Riverview House, Uxbridge

Class AA Upward Extension Application

Project Title:	Riverview House, Uxbridge
Project Ref:	1153
Report Title:	Class AA Upward Extension Application
Report Ref:	P932
Revision:	0
Date of Issue:	September 2022
Purpose of Issue:	Information
Compiled By:	Beatriz Antuna Tentor
Reviewed By:	Ben Paterson
Review Date:	12-09-22
File Location:	-

Project Title: RIVERVIEW HOUSE, UXBRIDGE
Project Ref: 1153
Status: PLANNING
Scale: 1:100 / A1
Sheet Title: GA PROPOSED THIRD FLOOR PLAN
Sheet Ref: P133 / 0

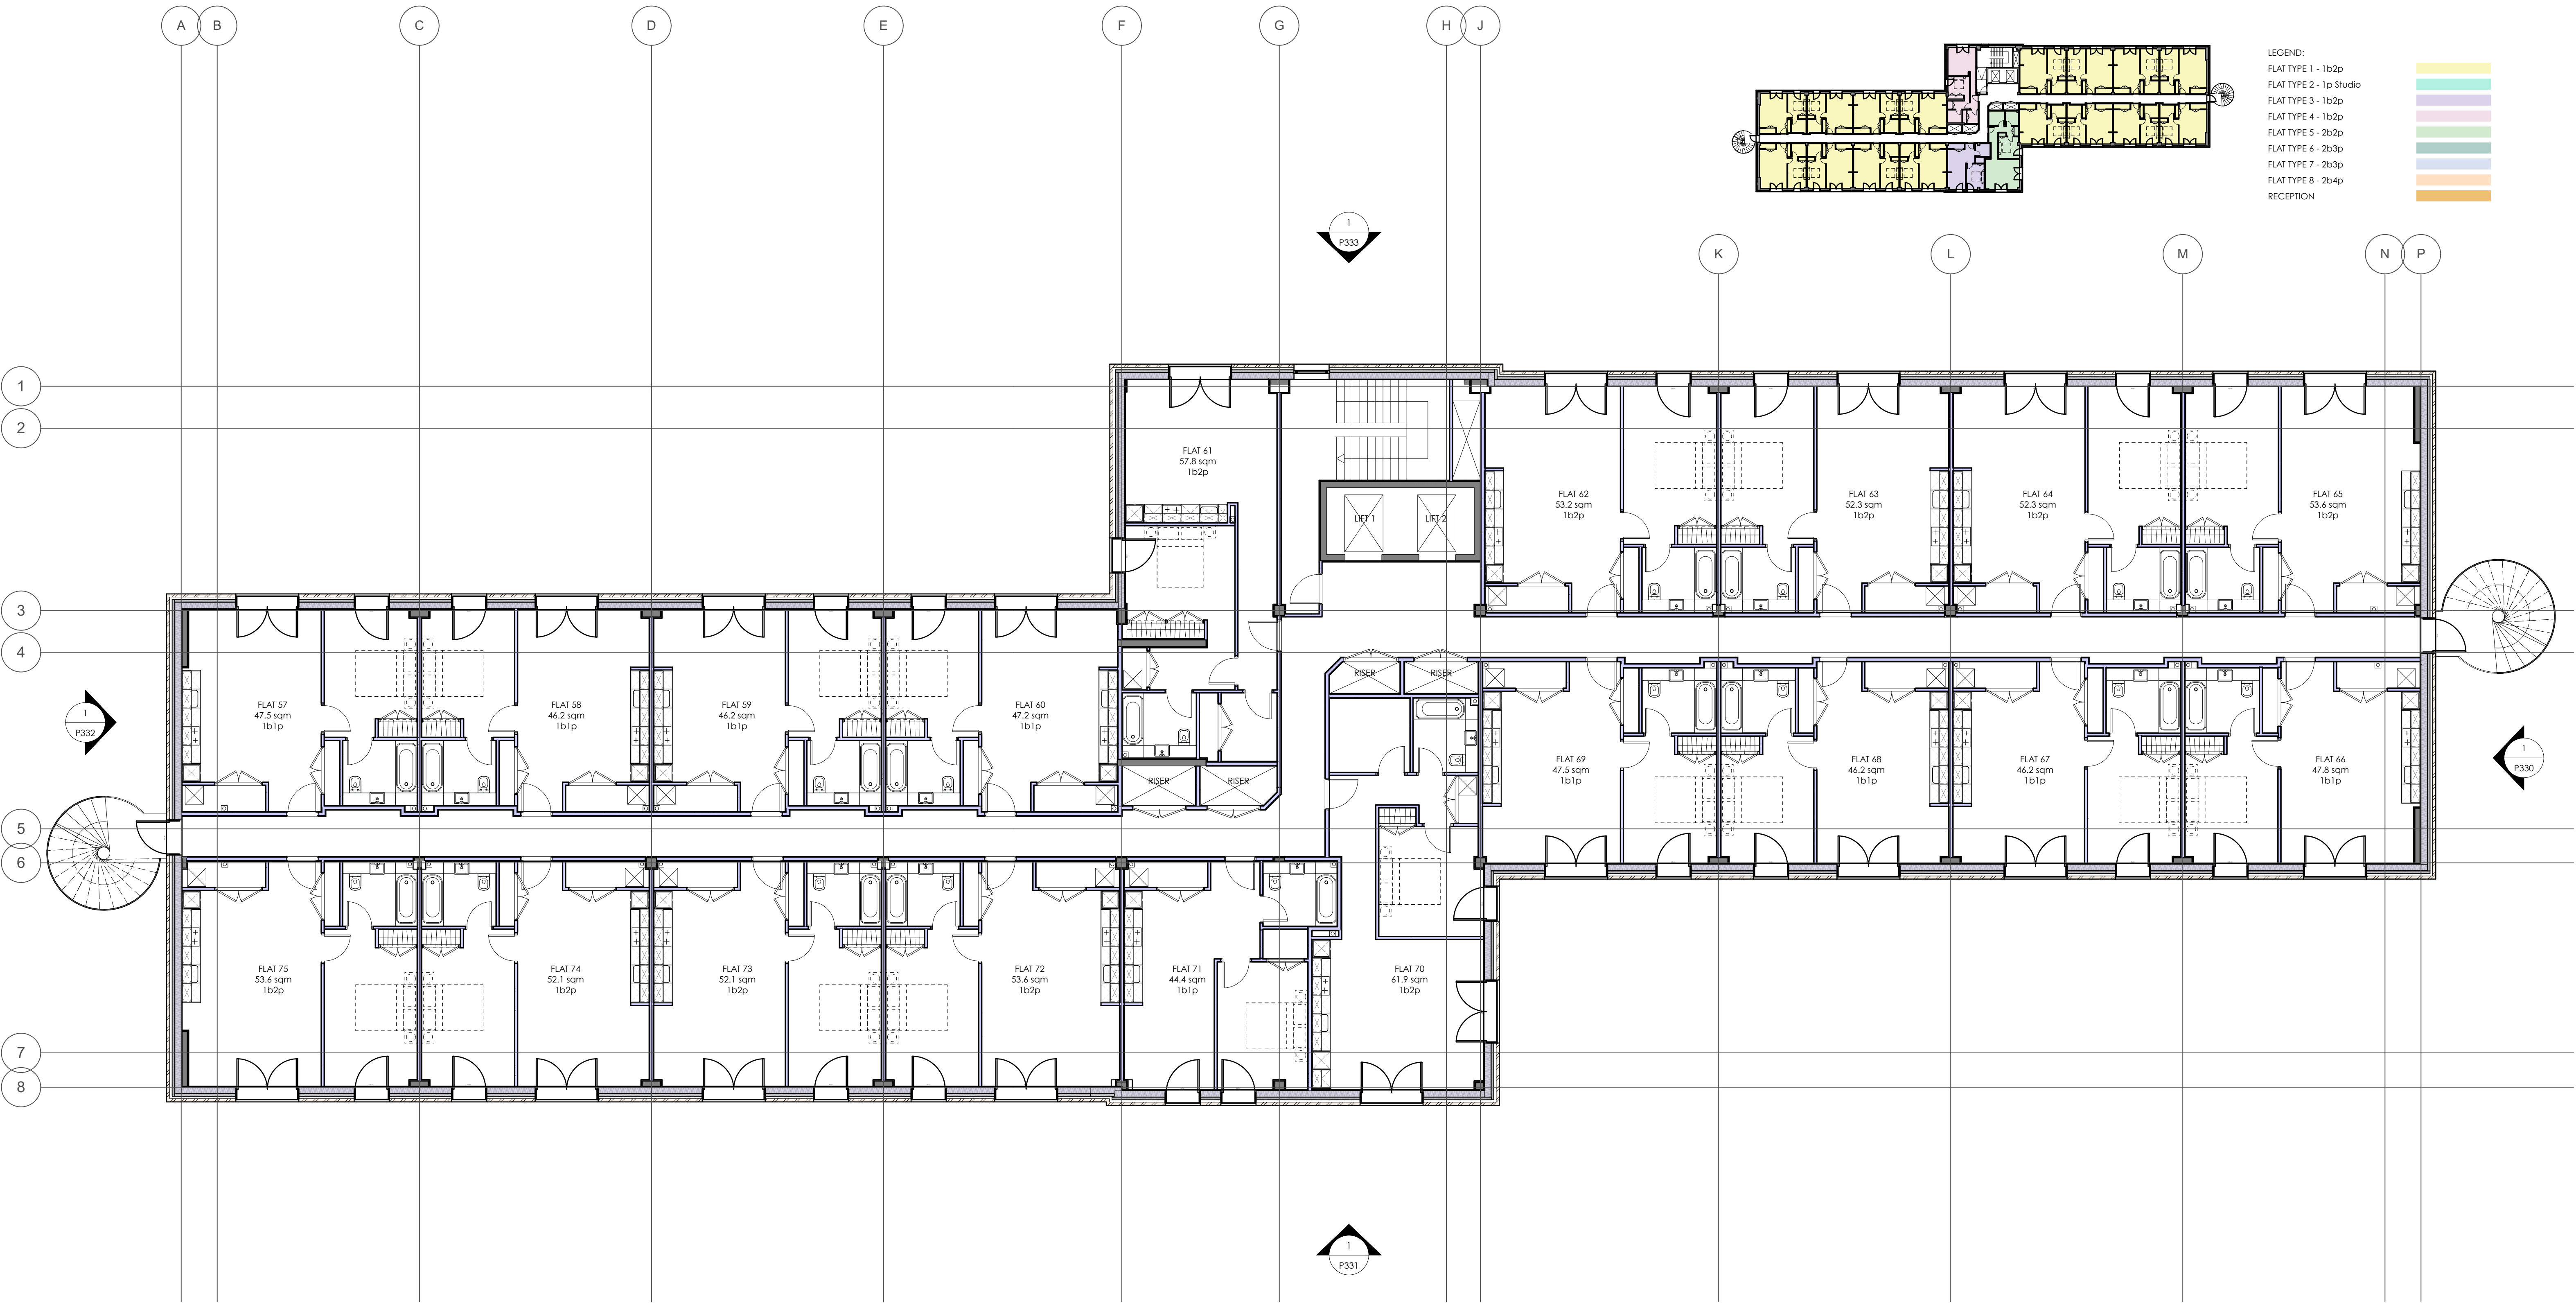
- The arrangement of apartments on the fourth floor is consistent with the consented scheme where the predominant changes occur along the internal wall of apartments where the width of the corridor has narrowed slightly to allow for generally 1200mm clear wall-to-wall, with passing spaces 1500mm in width. The naming conventions of the individual apartments is consistent with the NDSS and the previous application.

- Minor internal modifications of apartments to create improved, more open plan living accommodation, with better access to storage.
- Rationalised arrangement of bathrooms and coordination of services between the ground and fourth floors.

- Modification of Apartment 61 (left-hand side of the stair core) owing to the continuation of the structures from the floors below.
- Modification of risers from advise from the MEP consultant.

- Modification of the internal layout of apartment 70, following changes to the arrangement of the service risers.

Project Title: RIVERVIEW HOUSE, UXBRIDGE
Project Ref: 1153
Status: PLANNING
Scale: 1:100 / A1
Sheet Title: GA PROPOSED FOURTH FLOOR PLAN
Sheet Ref: P134 / 0

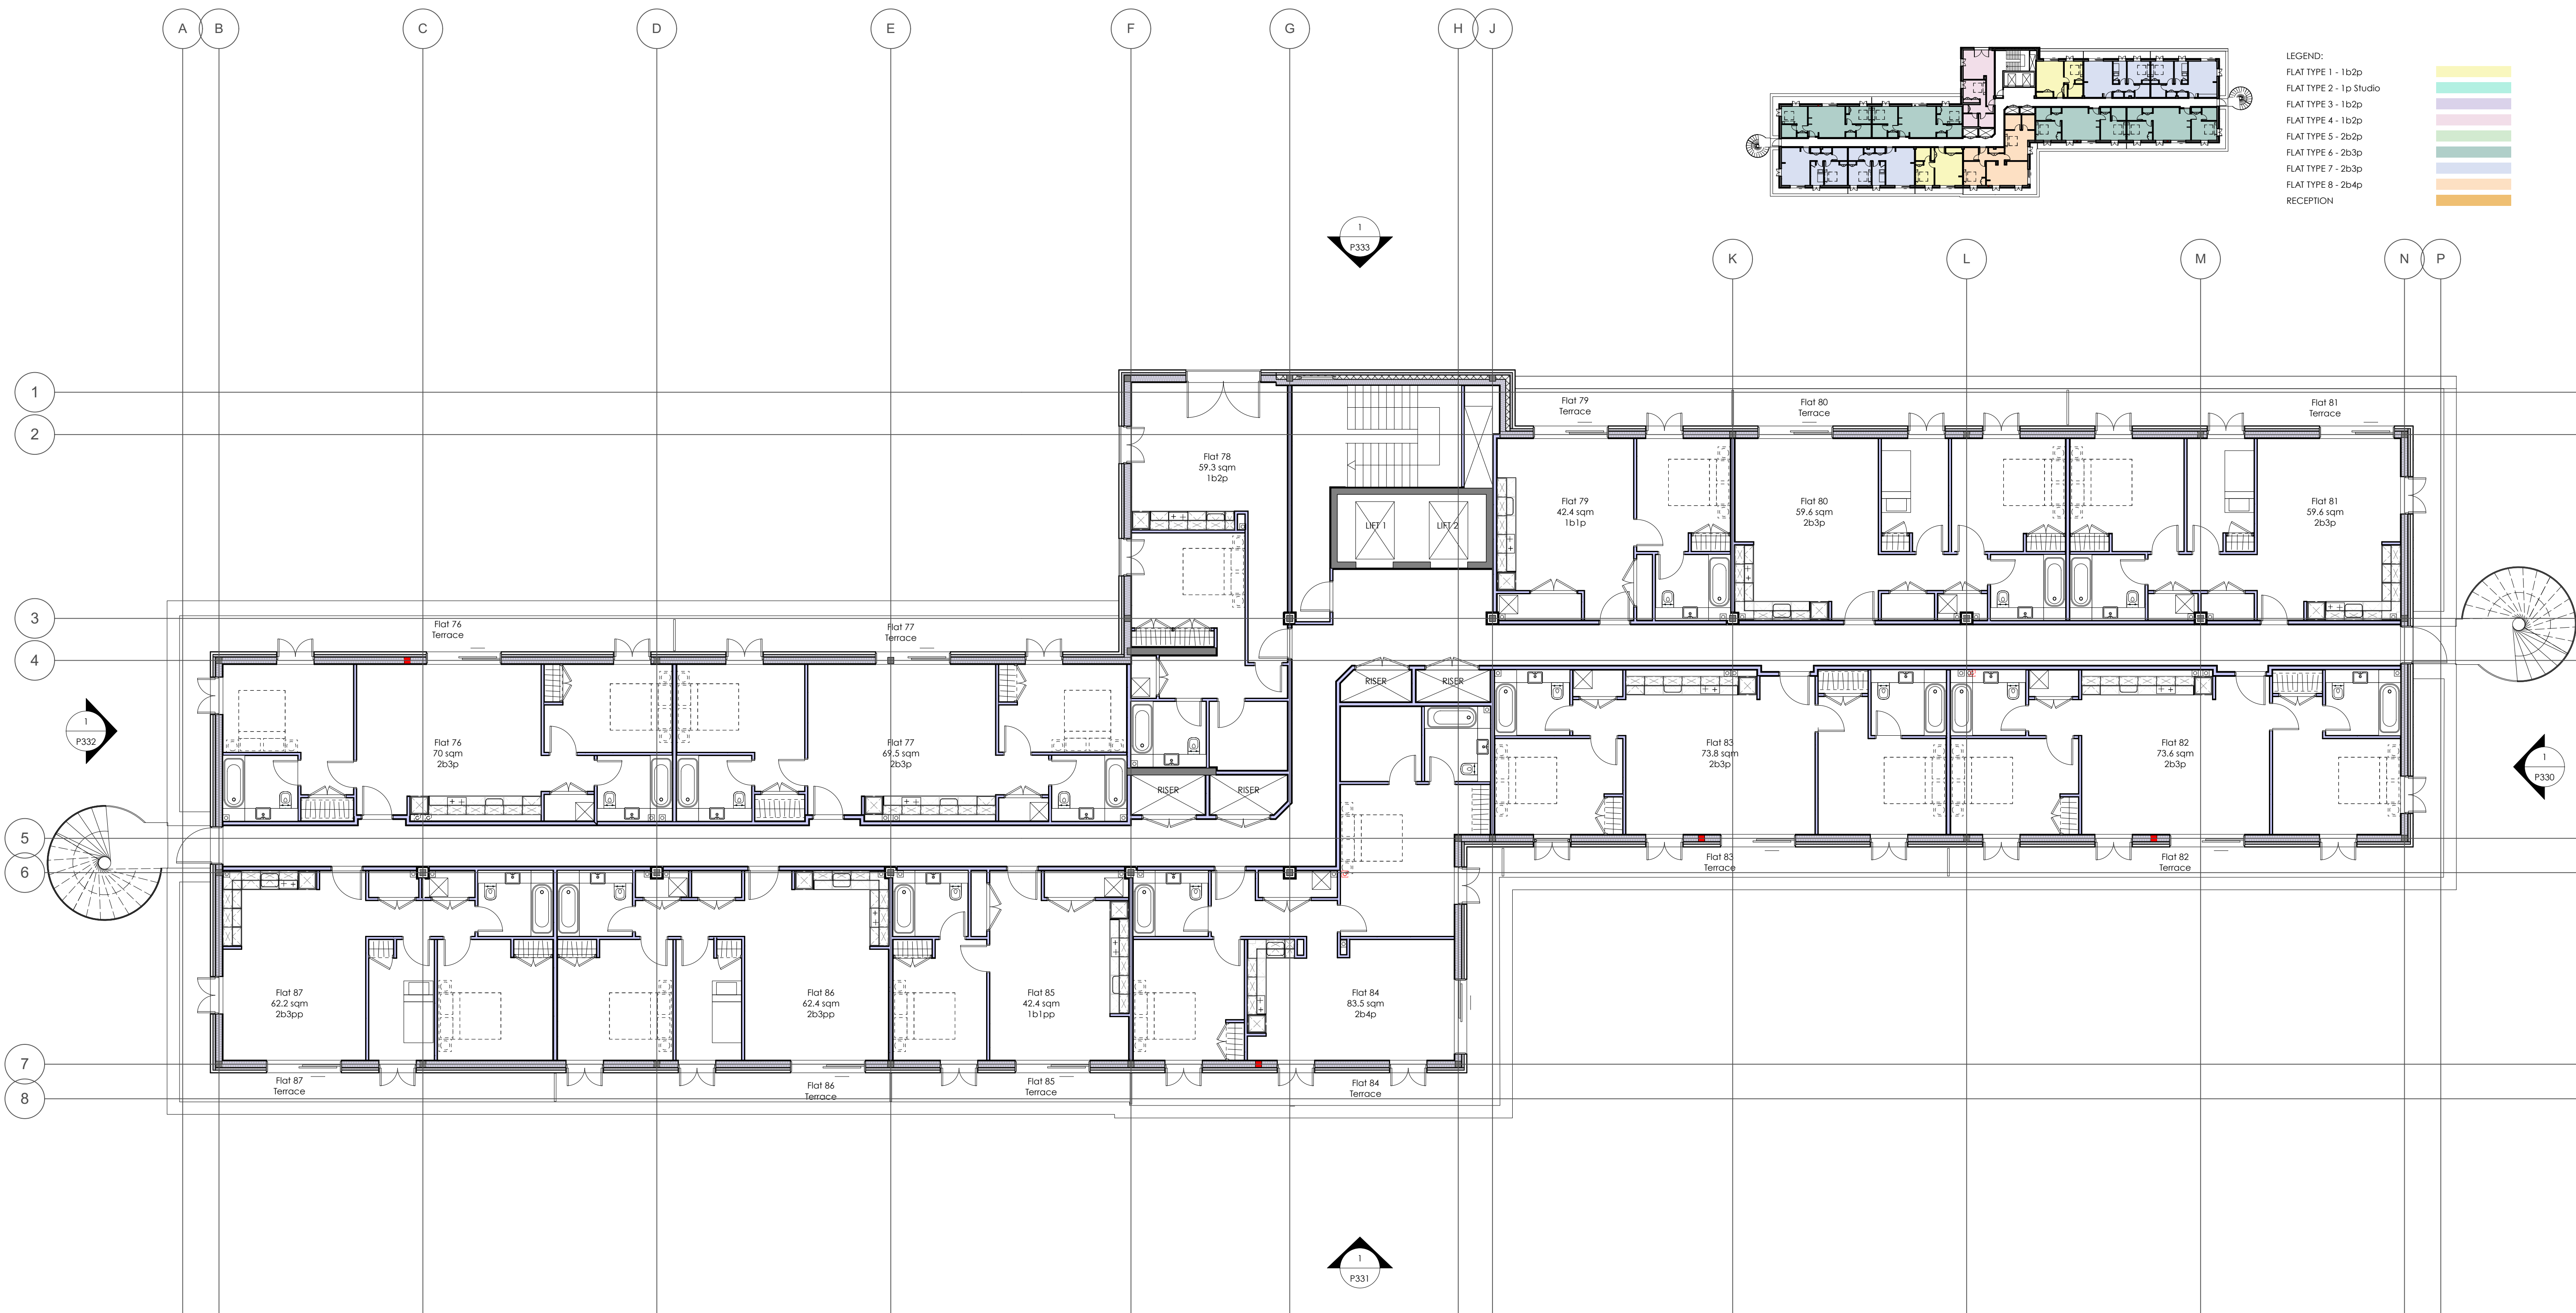
- Parapet increased in depth from what appears to be 100mm for buildability purposes.
- Changes occur along the internal wall of apartments where the width of the corridor has narrowed slightly to allow for generally 1200mm clear wall-to-wall, with passing spaces 1500mm in width. The naming conventions of the individual apartments is consistent with the NDSS and the previous application.

- Changes in the internal arrangement of the 2b3p apartments to the north side of the west wing and to the south side of the east wing. The primary drivers for changes included the alignment of services with the floors below, creating a more modern arrangement of bedrooms and bathrooms either side of the central living space.

- Modification of Apartment 78 (left-hand side of the stair core) owing to the continuation of the structures from the floors below.
- Revised riser positions and sizes following MEP advice.

- Changes in the arrangement of the consented fenestration, where once the depth of the proposed parapet has been included, sliding doors and smaller Juliet balcony doors are more appropriate to provide access onto the terrace.
